CONSULTANT ADVICE NOTICE

Project: Monaro Cluster - Hindmarsh

CAN No: G-003[1.4]

Reference is made to the response submissions from the Department of Planning, Industry and Environment (DPIE), - Queanbeyan-Palerang Regional Council and Transport for NSW (TfNSW) with respect to SSDA submission for the New High School in Jerrabomberra (Reference SSD – 24461956).

Project
 High School in Jerrabomberra
 ENVIRONA DRIVE,
 JERRABOMBERRA NSW 2619
 Drawing Title
 STORMWATER DRAINAGE
 PLAN - SHEET 1

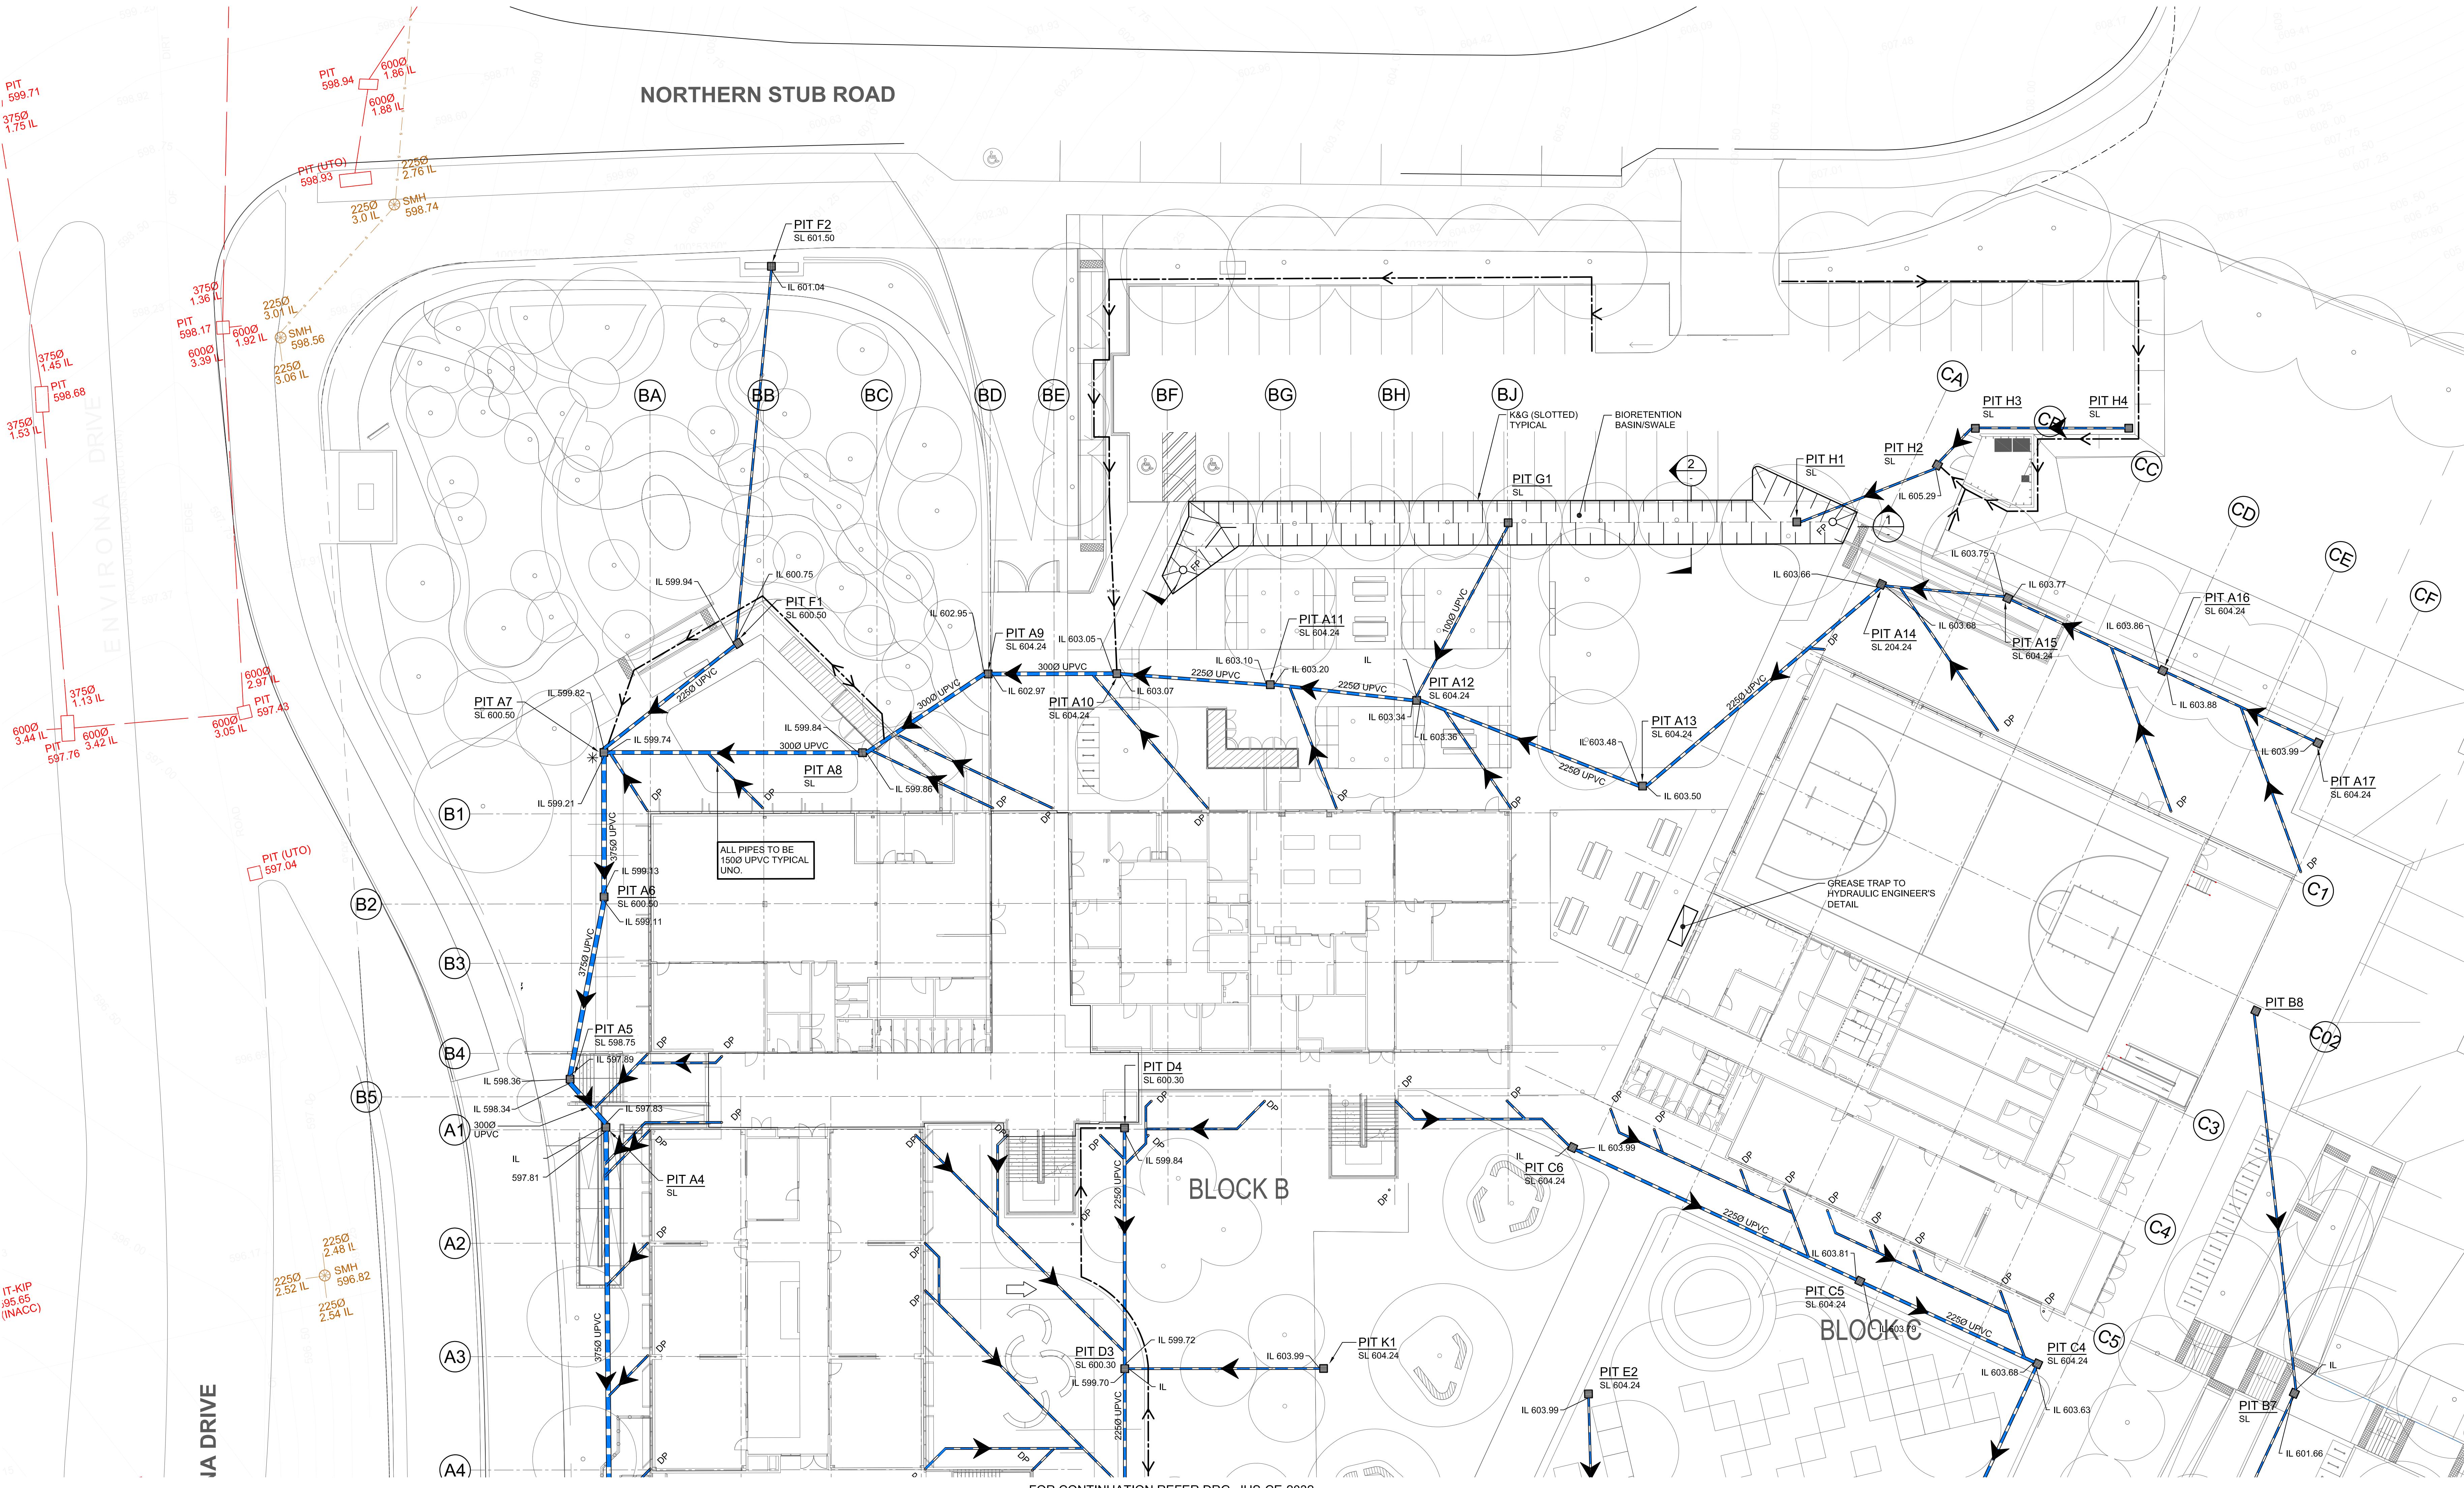
2.1.3 Storm Water

The high school development site can be serviced by a storm water connection to the recently constructed pit (G02) adjacent to the Bus Lane with a 600mmØ RCP drainage pipe connecting to the new infrastructure line in Environa Drive.

The proposed development of the site will increase runoff, thus a stormwater management plan demonstrating the proposed development will not exceed pre-development runoff flow for both 20% and 1% storm events is required in accordance with Council's D5 Stormwater Drainage Design specification, and water quality in accordance with Council's D7 Erosion Control and Stormwater Management Design specification and corresponding computer modelling.

The provided civil plans support the construction of an on-site detention (OSD) tank to accept stormwater from impermeable areas, which is a necessary requirement for this development.

Refer to response to 2.2

QPRC Submissions		
2.2	<p><u>Recommendations</u></p> <p>That the consent authority impose conditions requiring:</p> <ul style="list-style-type: none">• Preparation of a hydraulic design plan providing details of the required sizing for all water, sewer and stormwater services required for the site.• The preparation of an on-site detention design to limit stormwater discharge from the site to pre-development flows. <p>That all connections and alterations to Council's utility services are inspected by Council staff prior to backfilling.</p>	<p>As part of NDY's phase 4 design packages, a hydraulics services site plan (as recommended by Council) was detailed which highlights the location and sizing for the water and sewer services for the site (note: below-ground stormwater is contained within the civil engineering package). The hydraulic services site plan has been appended to this CAN in Appendix C.</p>
